Doma Holdings (NSW) Pty Ltd  
4/3 Sydney Avenue  
BARTON ACT 2600

Project 91034.00  
27 October 2017  
R.006.Rev0  
CB:MB:plh

**Response to Newcastle City Council Comments  
Proposed Residential Tower Development  
50 Honeysuckle Drive, Newcastle**

Landscape Elevation C-C | 1:75 @ A1

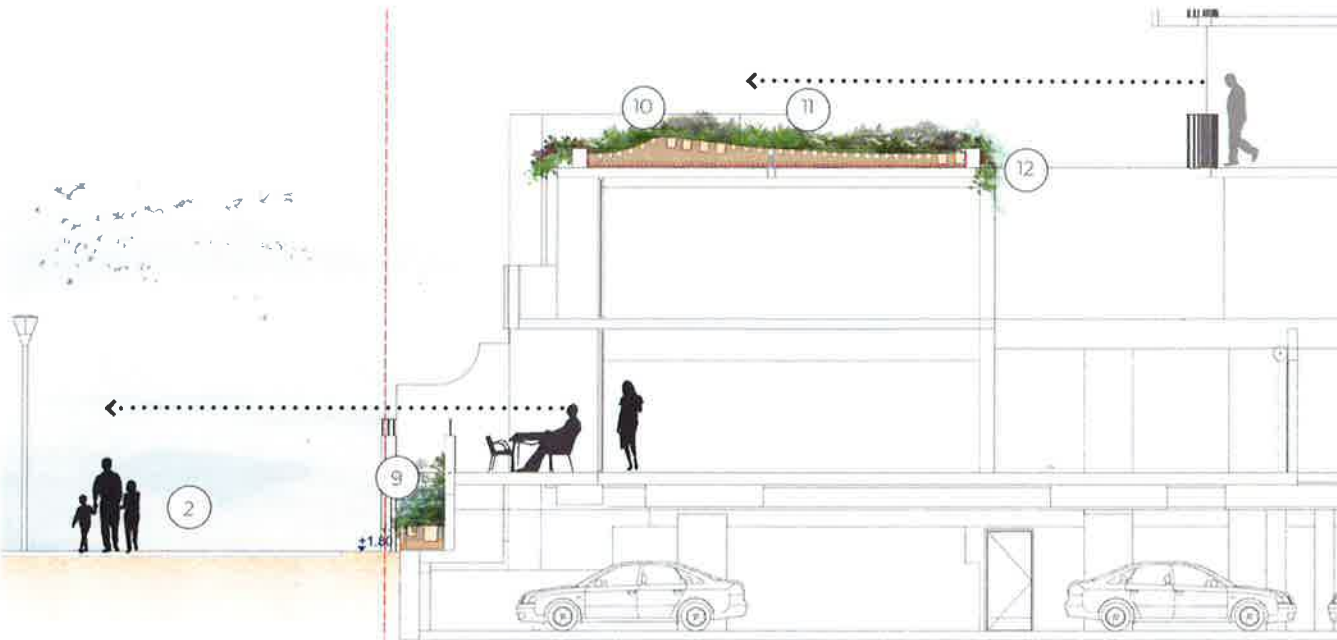
The principle of “minimal access to soil” has been adopted in the landscape design for the proposed development. The landscape drawings include “Compliance with Contamination Site Audit Statement” and indicate the following:

- All landscaping to be installed within approved imported soils (no planting within existing potentially contaminated soils);
- Provision has been made for a geofabric separation layer over existing site soils within landscape areas.

- General absence of contaminating activities since site remediation in 2005 and preparation of the SAS and SAR (i.e. construction of a carpark);
- Comparison of the results of previous and current site investigations to current contaminated land guidelines (i.e. current site conditions are commensurate with those identified in previous investigations (post remediation) and those considered in the initial SAR and SAS);
- Consideration of the proposed development (i.e. minimal access to soils due to site structures and pavements, and the use of imported approved soils for landscaping with provision for a geofabric separation layer as indicated on the landscape drawings).

The site is therefore considered to be suitable for the proposed development subject to appropriate conditions of consent, commensurate with the conditions presented in the 2005 Site Audit Statement and Report (i.e. minimal soil access and no beneficial use of groundwater).
